Our Reference: DOC20/607708-26

Luddenham Resource Recovery Facility (SSD-10446) 275 Adams Road Luddenham NSW (Lot 3 DP 623799) – Request for advice and recommended conditions

Figure 4.1 Water management system layout

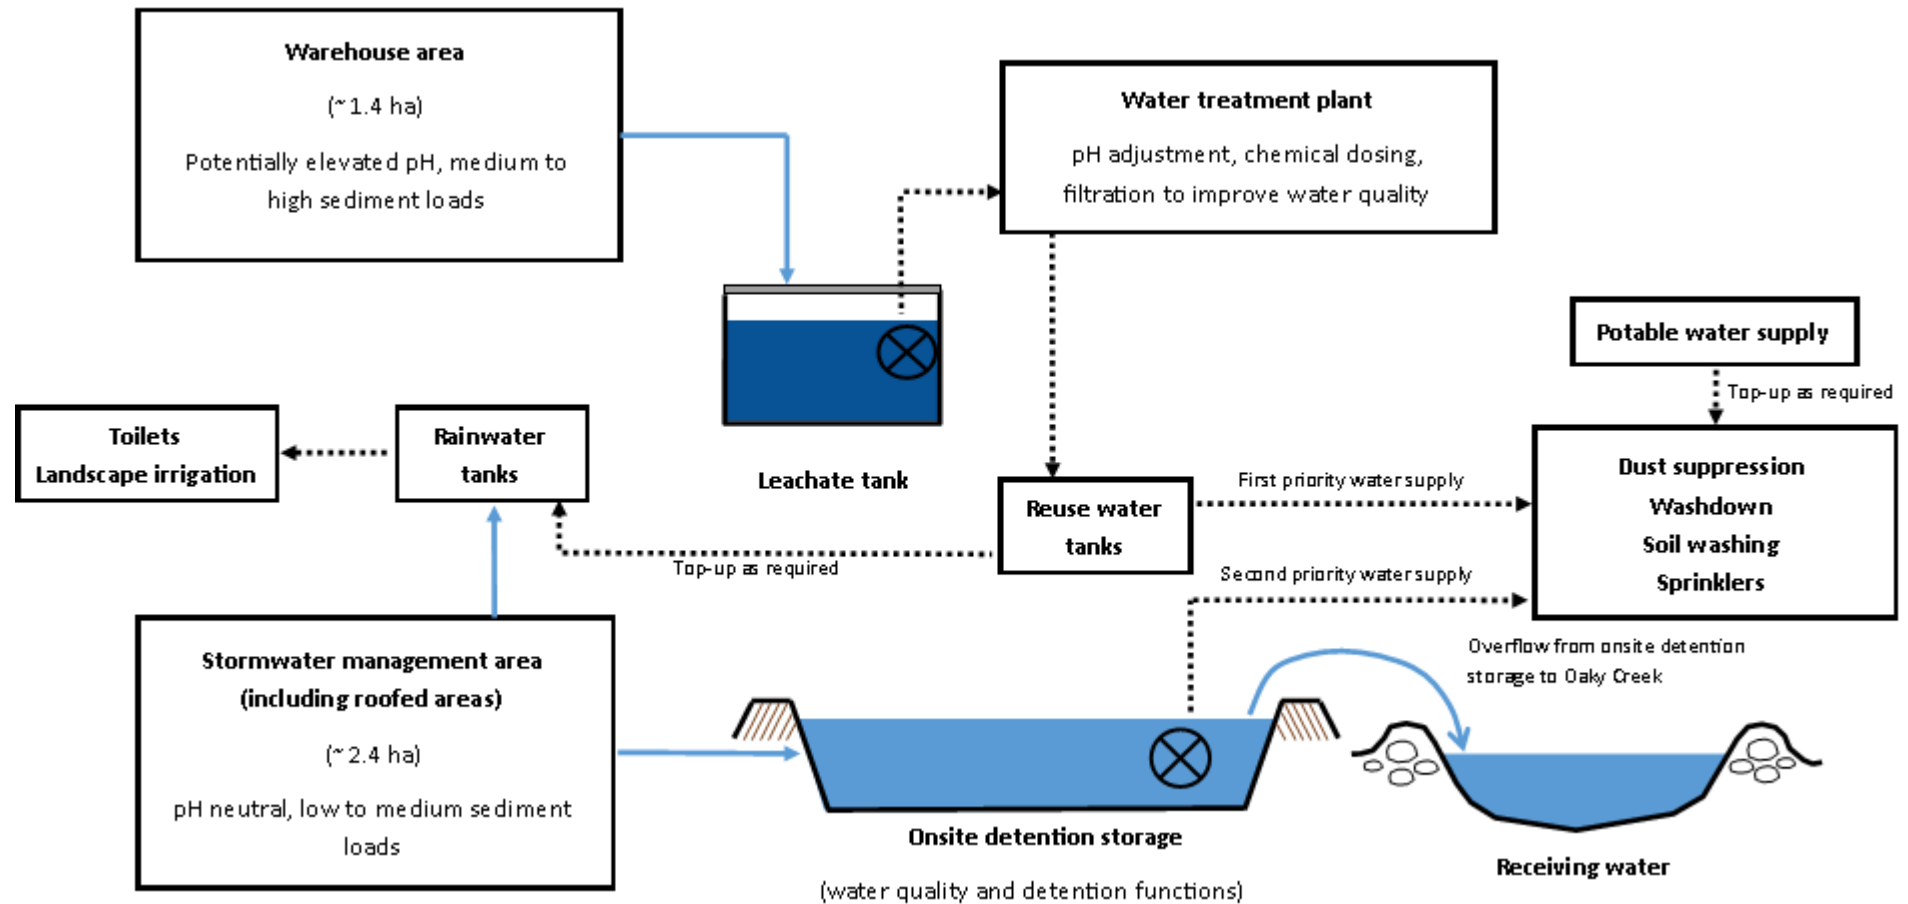
The SWA and EIS details that leachate from within the warehouse will drain to the Leachate Tank (130KL). Contaminated water within the Leachate Tank will be directed to the Water Treatment Plant, and then stored within the Reuse Water Tank (100KL) prior to reuse onsite. The maximum treatment rate of the Water Treatment Plant is 6L/sec. The EIS has not demonstrated that there is enough holding capacity in the leachate and water reuse tanks. There are no contingency measures if the treatment plant is offline, operating at a reduced efficiency or unable to treat water to the appropriate quality for the nominated end-uses.

The EIS and SWA detail that the water treatment plant will use clarification with chemical dosing, chlorination and filtration. The expected input water quality and treated wastewater quality has not been provided. Untreated construction/demolition waste can leach the following pollutants:

The EIS proposes to use the recycled water for a range of end-uses within the enclosed warehouse where it would continue to be recycled. The EIS, however, also includes landscape irrigation as a proposed end-use for treated wastewater. Use of treated wastewater for irrigation requires that the water quality is characterised and the sustainability of irrigation considered and safely managed.

The overflow discharge quality from the on site detention OSD basin (OSD) has not been characterised. However, the EIS indicates that the OSD will only contain uncontaminated stormwater runoff from the site and will not receive any water from the Reuse Water Tank. If the OSD receives treated leachate water, the applicant will be required to characterise the discharges from the OSD and potentially apply for a licenced discharge point.

To account for this issue, the EPA recommends that the consent, if granted, include a condition where the Proponent must develop a Leachate Management Plan that includes contingency measures if the treatment plant is offline or unable to treat water to the appropriate quality for the nominated end-uses.

To account for this issue, the EPA recommends that the consent, if granted, include a condition where the Proponent must prepare an Irrigation Management Plan (IMP). The IMP should include, at a minimum:

- a characterisation of the expected quality of the untreated and treated wastewater including typical and maximum concentrations and loads of all pollutants likely to be present;
- consider the sustainability of irrigating the treated wastewater consistent with the Environmental Guidelines - Use of effluent by irrigation (DEC 2004)
- sufficient detail to demonstrate sustainable irrigation practices based on the treated wastewater characterisation and volumes to be irrigated
- proposed environmental monitoring measures and action-based trigger criteria that the proponent will implement to monitor the sustainability of the irrigation reuse scheme
- details of management practices the proponent will implement (e.g. application rates) to maintain sustainable hydraulic and pollutant loads.

Figure 6.1 Contribution to exceedances for cumulative 24-hour PM₁₀ concentration at R3

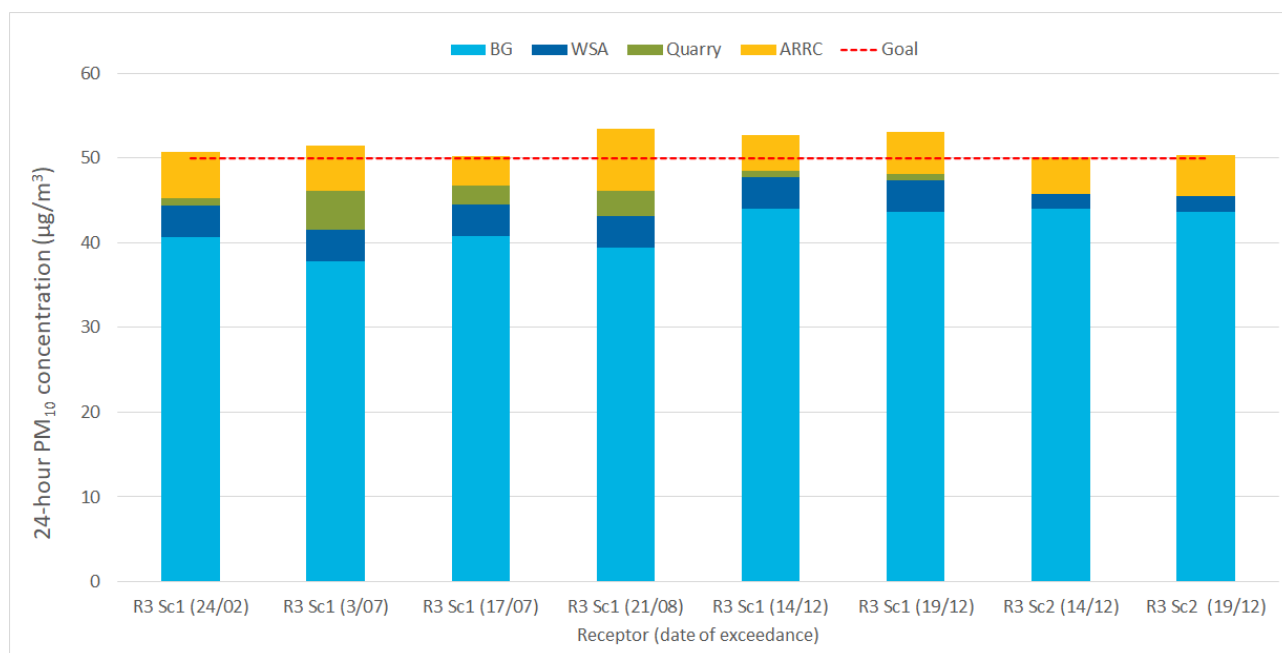
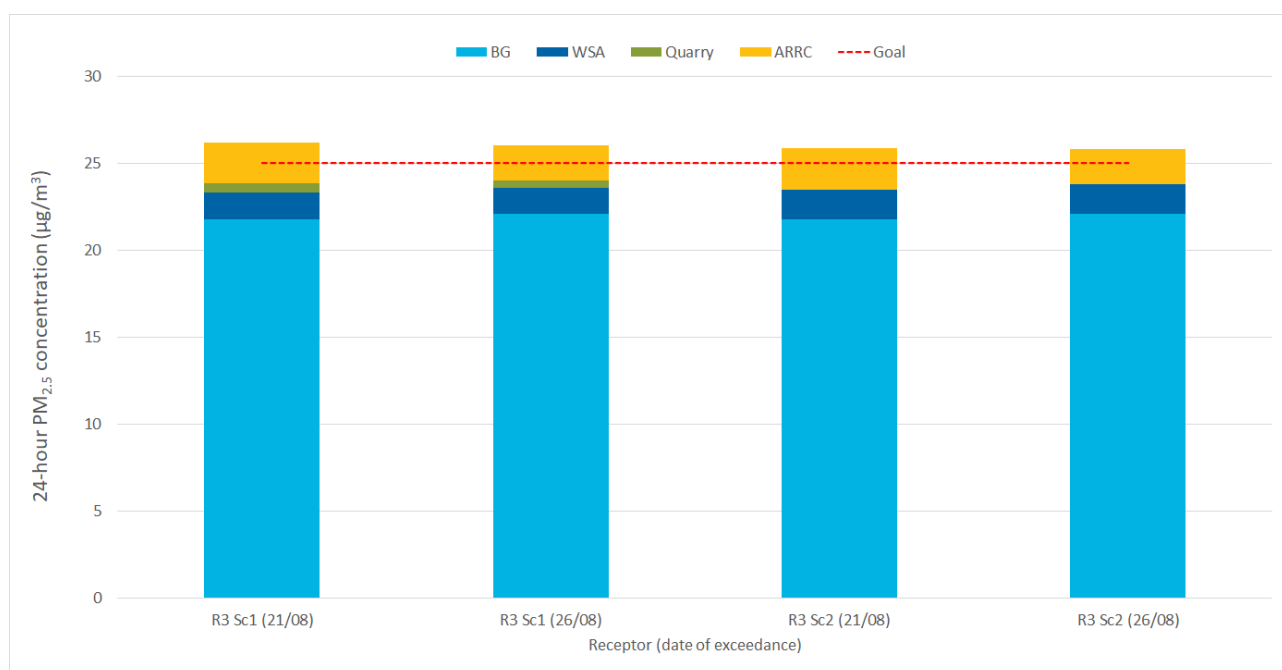
a) Assessment has not sufficiently identified the measures to manage predicted exceedances.

The AQIA concludes that *“The most effective way to control potential exceedances will be to control wheel generated dust from trucks entering and exiting the site, which is the largest contributing source. This will be achieved through the installation of a wheel wash (which has not been incorporated into emission reduction measures for modelling) and through deployment of a street sweeper twice a day. Both measures will act to reduce the silt loading of the road surface and will significantly reduce dust emissions from truck movements”*

- Vehicle movements on sealed roads account for ~45 % of total PM_{2.5} emissions assessed from the Premises. Diesel emissions from onsite equipment account for ~51% of PM_{2.5} emissions from the Premises. As such particulate emissions from diesel combustion represent the highest PM_{2.5} emission source from the Premises.
- A 70% control factor has been applied to the estimated emissions for vehicle generated dust emissions. The 70% control factor adopted is stated as being for water flushing/street sweeping. As such the assessment has accounted for the measures discussed in the conclusion portion of the AQIA.
- No assessment of reductions in particulate matter emissions from diesel equipment that could be achieved has been conducted. Diesel particulate matter emissions represent the highest uncontrolled PM_{2.5} emission source in the emissions inventory.

Additionally, it is noted that diesel combustion emissions have been based on a series of assumptions, including assuming that off-road diesel equipment will achieve a Tier 2 emission performance. The EPA considers that reduction in particulate matter emissions from diesel equipment could be achieved:

The AQIA has not benchmarked proposed non-road diesel emission performances against best practice, considered the emission reductions that could be achieved through implementation of better performing diesel engines, or demonstrated that particulate matter emissions have been reduced as far as practicable.

The EPA recommends the AQIA be revised to:

- i. Identify additional mitigation measures to manage predicted exceedances, and:
 - reduce PM_{2.5} annual average contributions from the Premises
 - reduce 24-hour average PM_{2.5} and PM₁₀ contributions from the Premises
- ii. Revise the assessment accounting for the additional mitigation measures identified in (i) to reduce incremental ground level concentrations.
- iii. Demonstrate that particulate matter emissions have been reduced as far as practicable.

In addressing the above items, consideration should be given to source contributions to predicted exceedances at assessed receptors, and source contributions to total emissions from the Premises.
